**Our ref:** NO/2021/113773/01-L01  
**Your ref:** 3/2021/0690  
**Date:** 01 September 2021

**PROPOSED CREATION OF CAR PARKING (INCLUDING LIGHTING) AND AREA OF  
SOFT LANDSCAPING TO REDUNDANT LAND BEHIND STANDS.  
CLITHEROE FOOTBALL CLUB, SHAWBRIDGE STREET, CLITHEROE, BB7 1LZ.**

**Environment Agency position**

Figure 1. Flood Risk Map

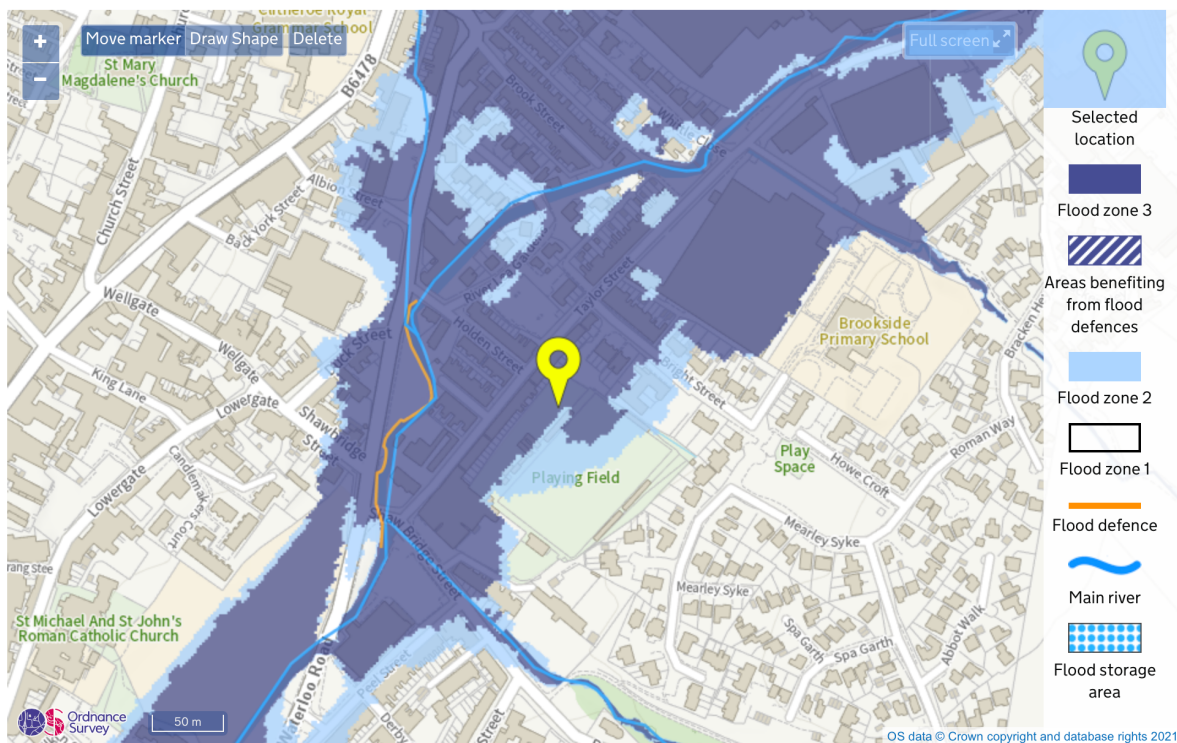
In the absence of an acceptable flood risk assessment (FRA) we object to this application and recommend that planning permission is refused.

The development is located within flood zone 3, an area at high risk of flooding. It is unclear whether ground levels have been altered and there has been little assessment of the impact the proposed works would have on flood risk. If ground levels have been raised, this is likely to displace water within the floodplain and increase flood risk elsewhere which is contrary to the NPPF.

The submitted FRA does not comply with the requirements for site-specific flood risk assessments, as set out in paragraphs 30 to 32 of the Flood Risk and Coastal Change section of the planning practice guidance. The FRA does not therefore adequately assess the flood risks posed by the development. In particular, the FRA fails to:

- consider how people will be kept safe from the identified flood hazards
- consider how a range of flooding events (including extreme events) will affect people and property
- consider the requirement for flood emergency planning including flood warning and evacuation of people for a range of flooding events up to and including the extreme event
- take the impacts of climate change into account. There is no assessment of the impact of climate change using appropriate climate change allowances. Please refer to '[Flood risk assessments: climate change allowances](#)' for more detail.

To overcome our objection, the applicant should provide ground levels for the site both pre and post development. They should also submit a revised FRA which addresses

the points highlighted above. If this cannot be achieved, we are likely to maintain our objection.
